Planning Application Ref: BE/137/19/RES

Location: The Cottage, Shripney Road, Bognor Regis, PO22 9PA

Description of works: Application for approval of phase 2 reserved matters following outline permission BE/63/17/OUT (as amended by BE/131/18/PL) for 20no. dwellings

Comments on Application:

Drawing Title
Floor Plans Plots 01-06

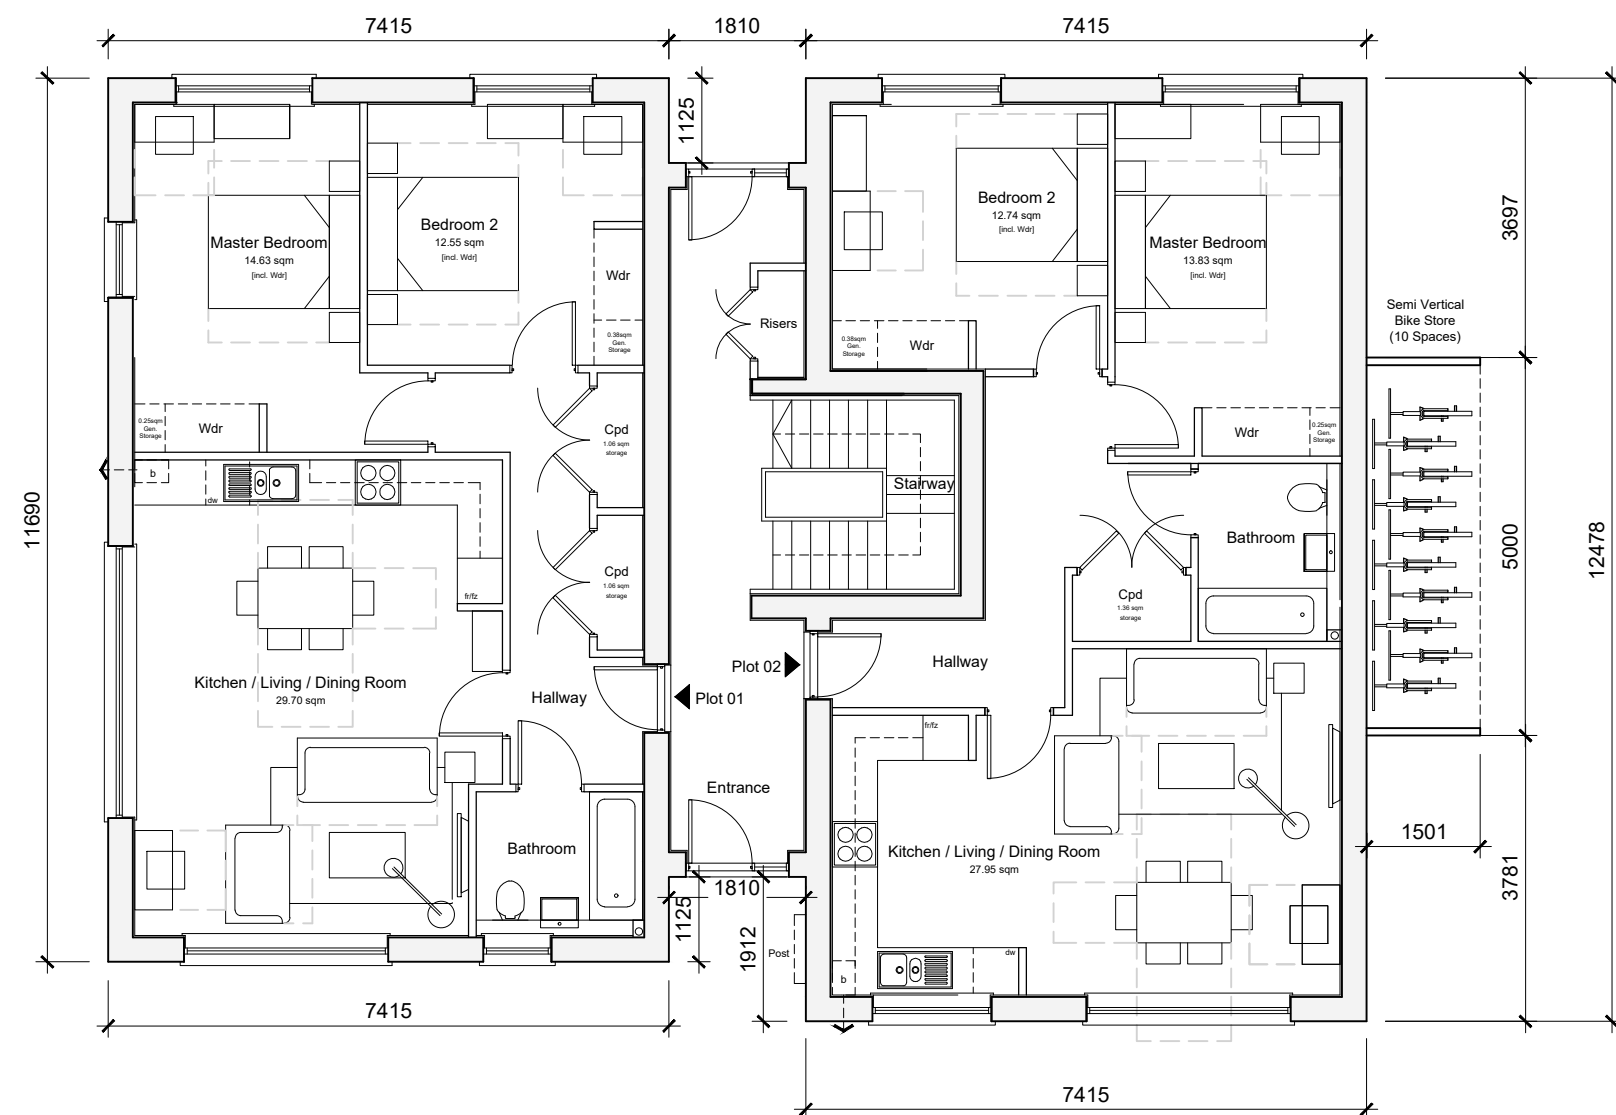
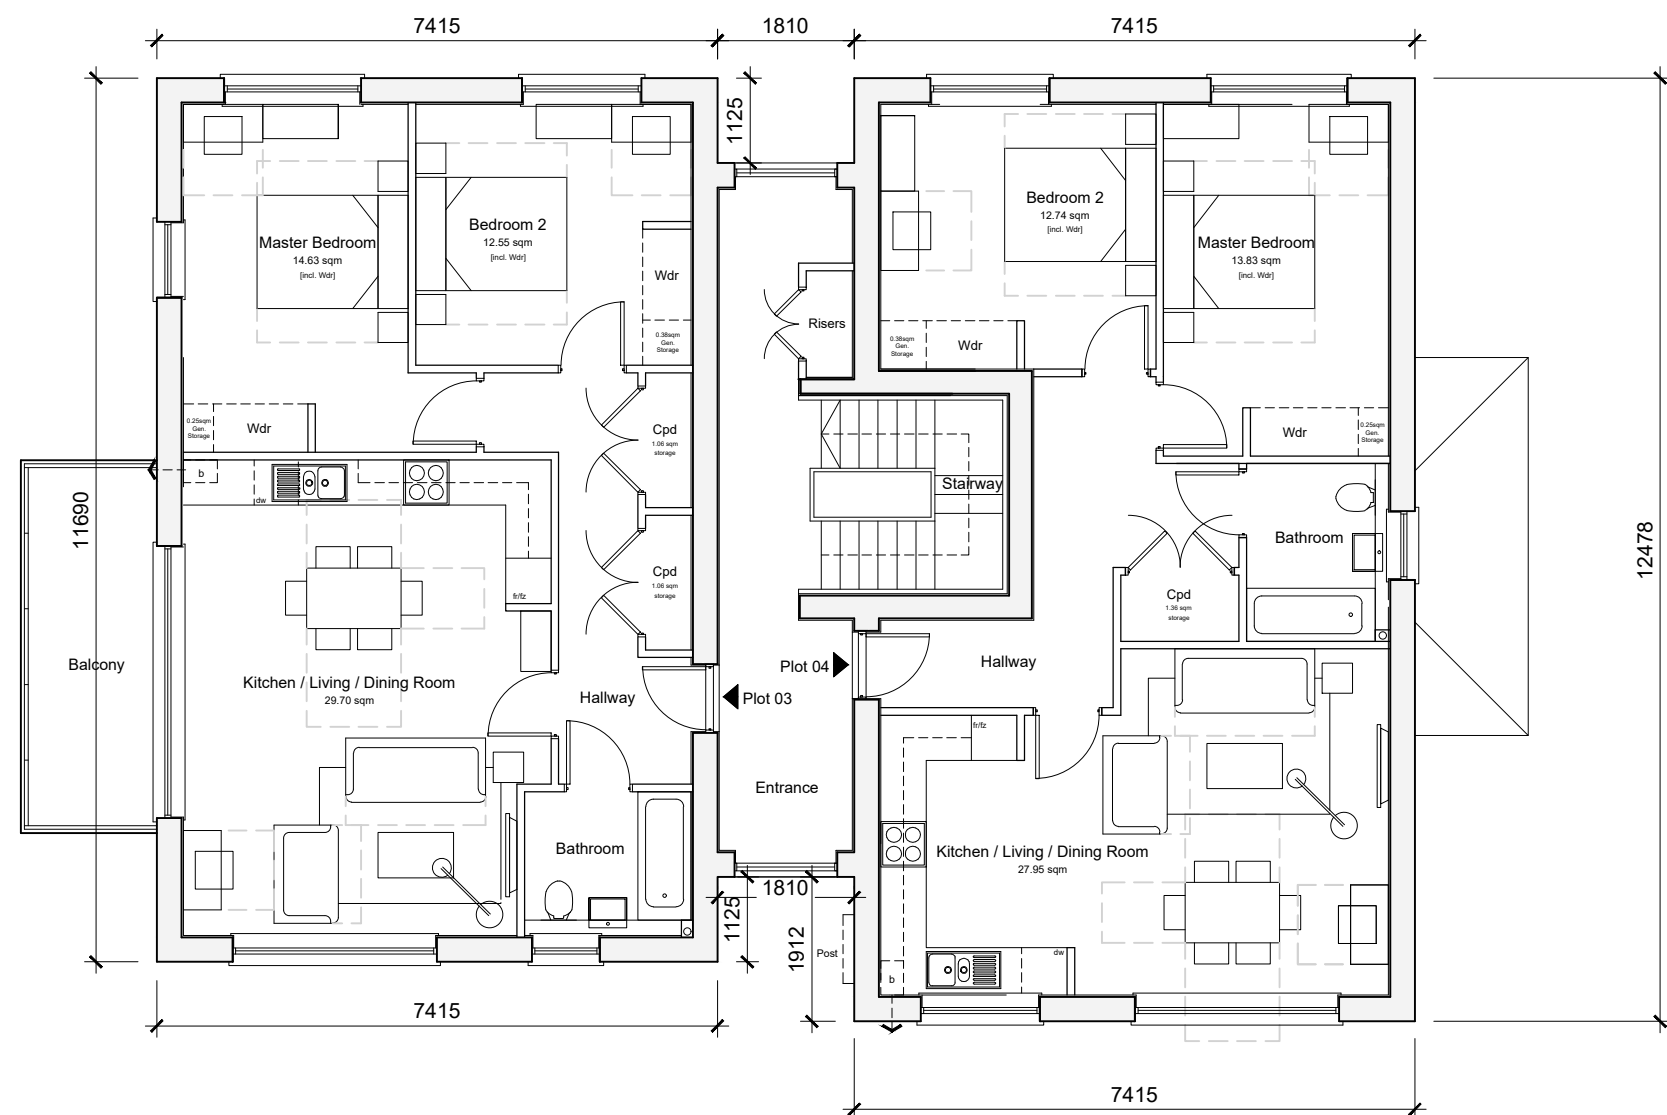
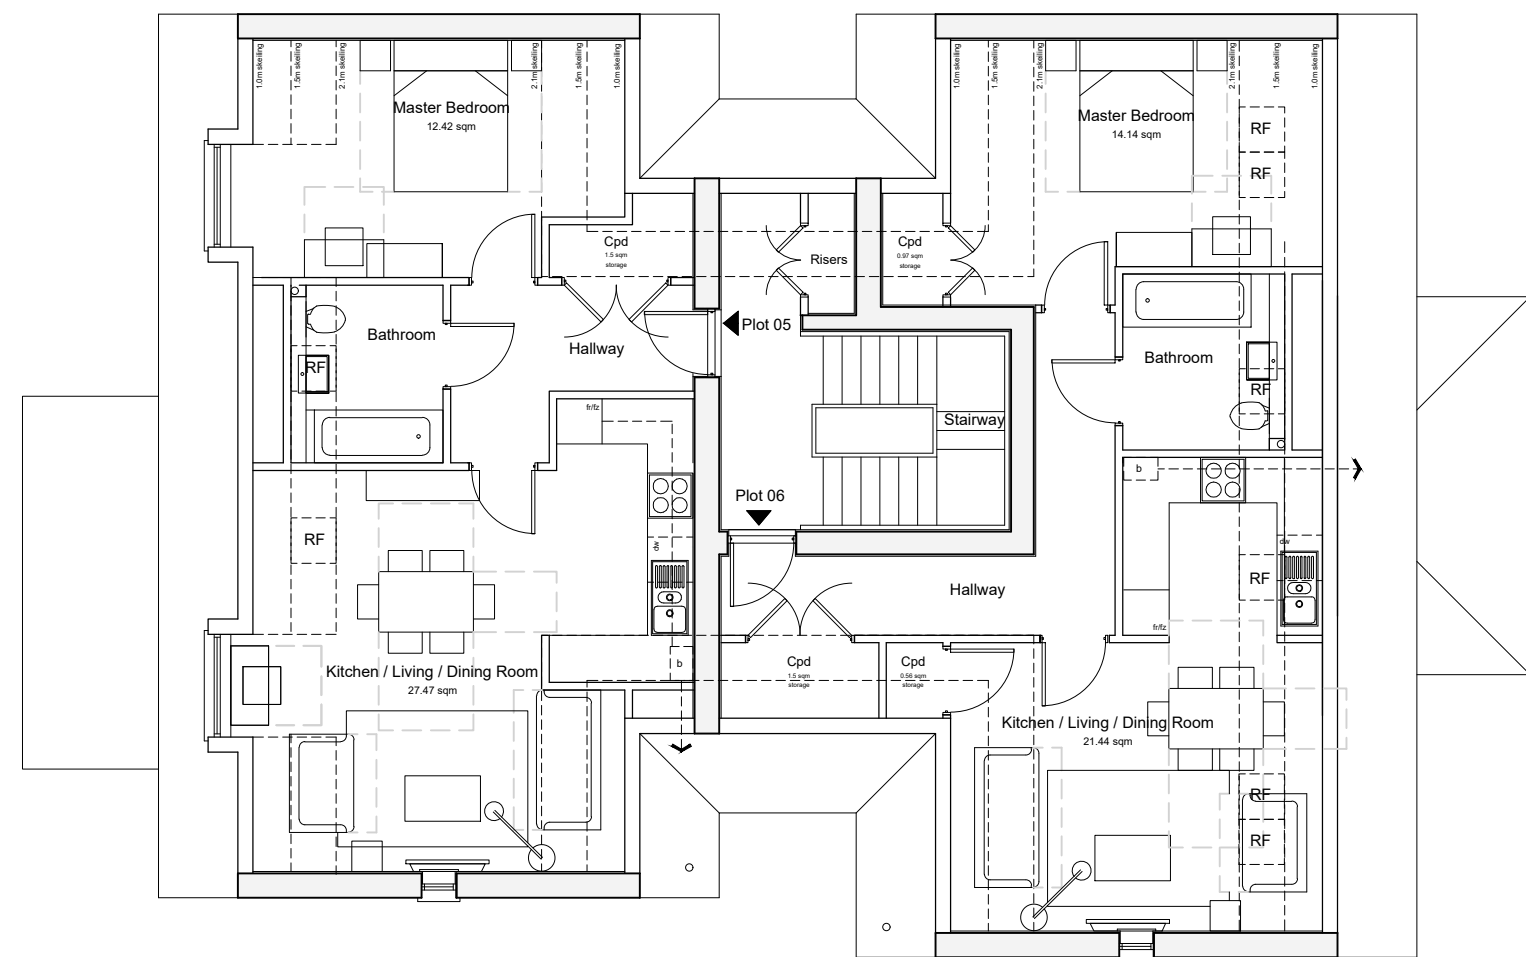
- It is apparent from the latest Proposed Site Plan (dwg.no. PL-003, Rev 4) that greater root protection area (RPA) incursion will occur at plots 01-06, 11 and 16. I find this unacceptable, especially given the progress which had been made to secure our arboriculturist's approval at Outline stage and as there is ample opportunity (no over-riding justification otherwise) to avoid RPAs. In respect of plot 16 again, T33 (TPO sycamore) will undoubtedly come under greater and hard-to-resist 'future residential pressure to prune', thus diminishing its position in the landscape.

- Foul water drains are proposed within the RPA of retained trees; to the rear of plots 01-06 and alongside plot 16, which I assume would involve damaging excavation work. Those trees to be affected are of significant screening value and/or a public amenity. This must be avoided and so the Foul Drainage Network needs revising at those locations.
Unresolved.

- **Resolved.** Some adjustments to the plot layout have been made to soften the impact of these intrusions, such that it is comparable in its overall effect on the tree population with the Outline stage scheme that won our arboricultural consultant's support.
